**Consultation Response from KC,
Highways Development Management****2022/92368 Land off, Liley Lane, Grange Moor, Huddersfield, WF4 4EN****Change of use of building and land from equestrian to dog care centre****Date Responded: 25-1-2023****Responding Officer: Mark Berry****Responding Ref: 16-2-10**

Drawing Number:
22-058-01A

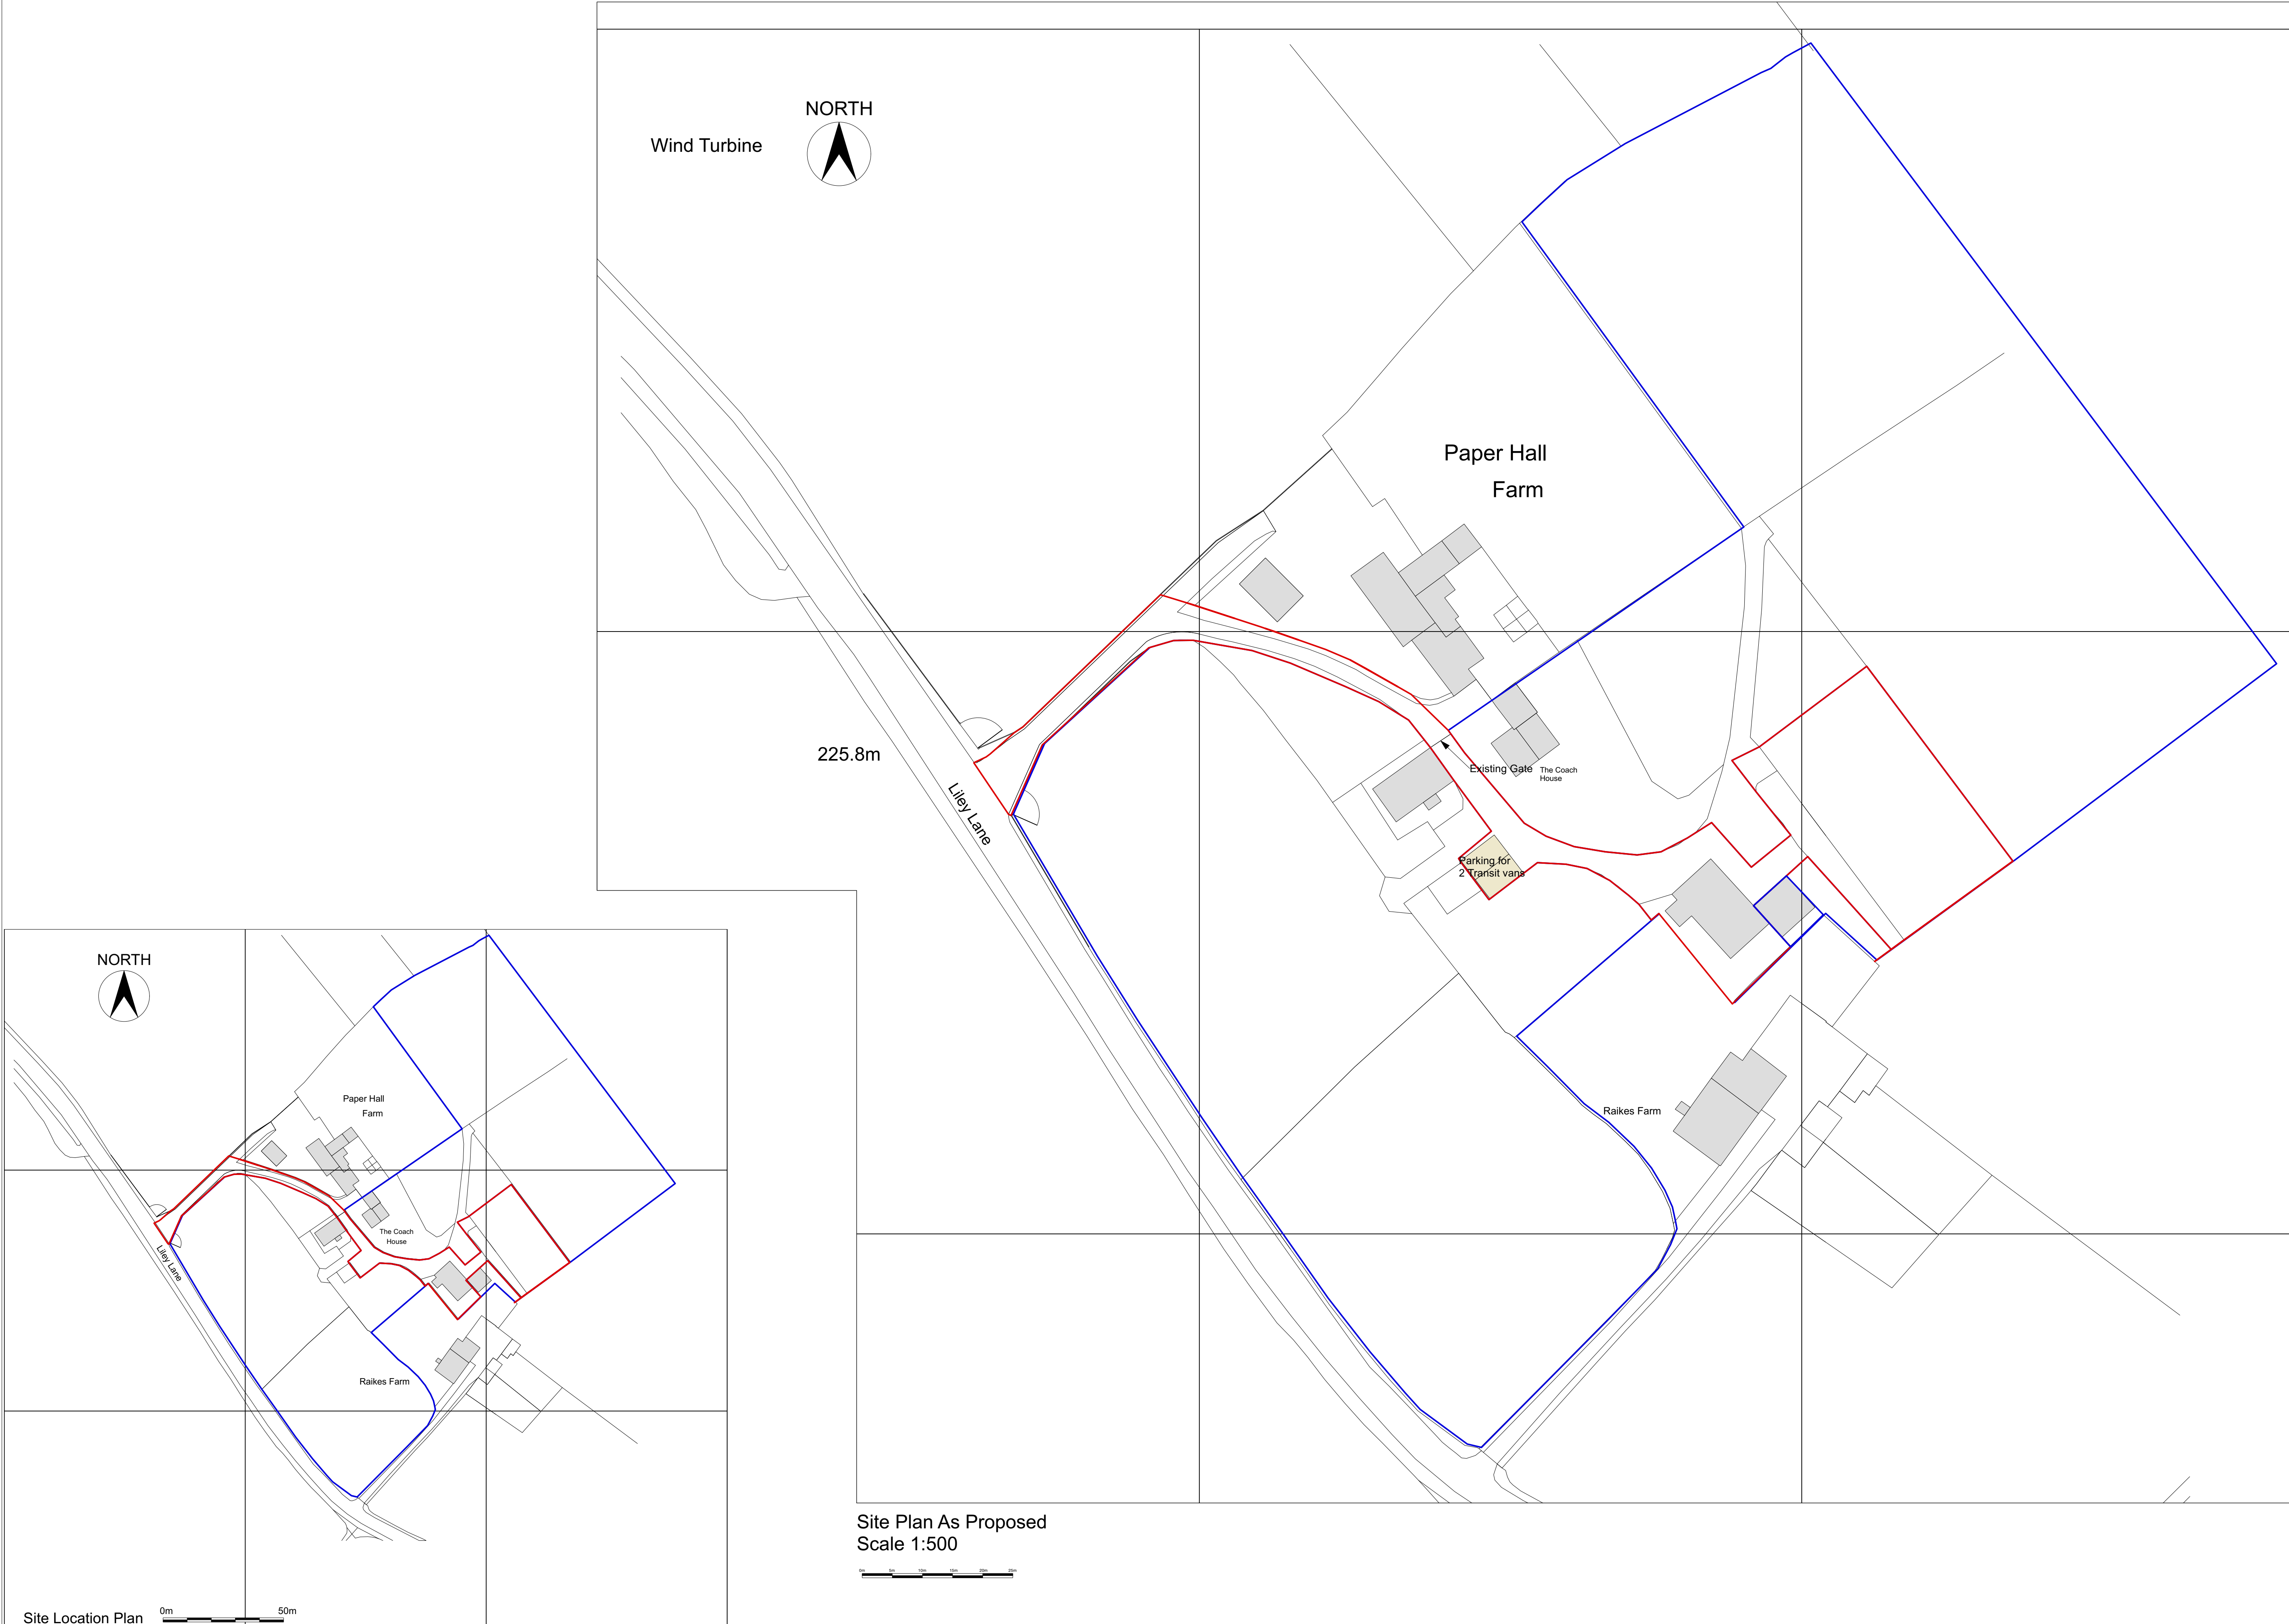
The visibility plays shown are 2.4m x 65m which is not in accordance with DMRB recommendations for a 40-mph speed limit. 90m is the recommended distance. In any case the sight lines should be based on speed surveys as the speeds along Liley Lane may be more than the speed limit at this location.

The sight line to the north is shown to run over land that is not within the red line boundary and not therefore within the applicant's control.

Given the proposed sub-standard visibility at the junction with Liley Lane this application should be refused on highway safety grounds.
